Rezoning Transportation Analysis

Petition Number: 2022-214

Revision Log:

Date	Description
05.24.2023	First Review (PDM)
06.21.2023	Second Review (DR)
07.26.2023	Third Review (PDM)

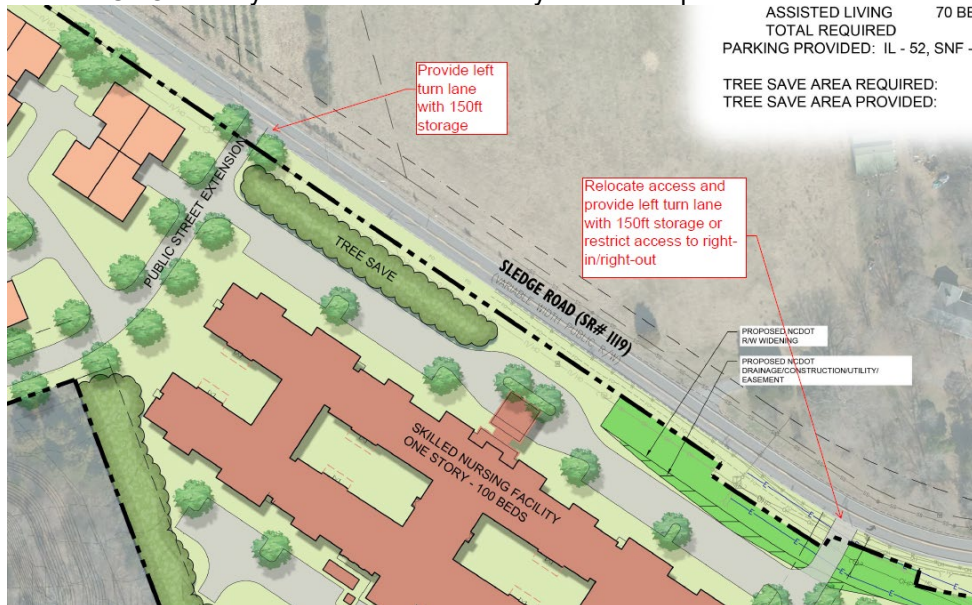
8. ~~Per coordination with NCDOT provide turn lane and access management modifications per the markup below to meet NCDOT Policy on Street and Driveway Access requirements.~~
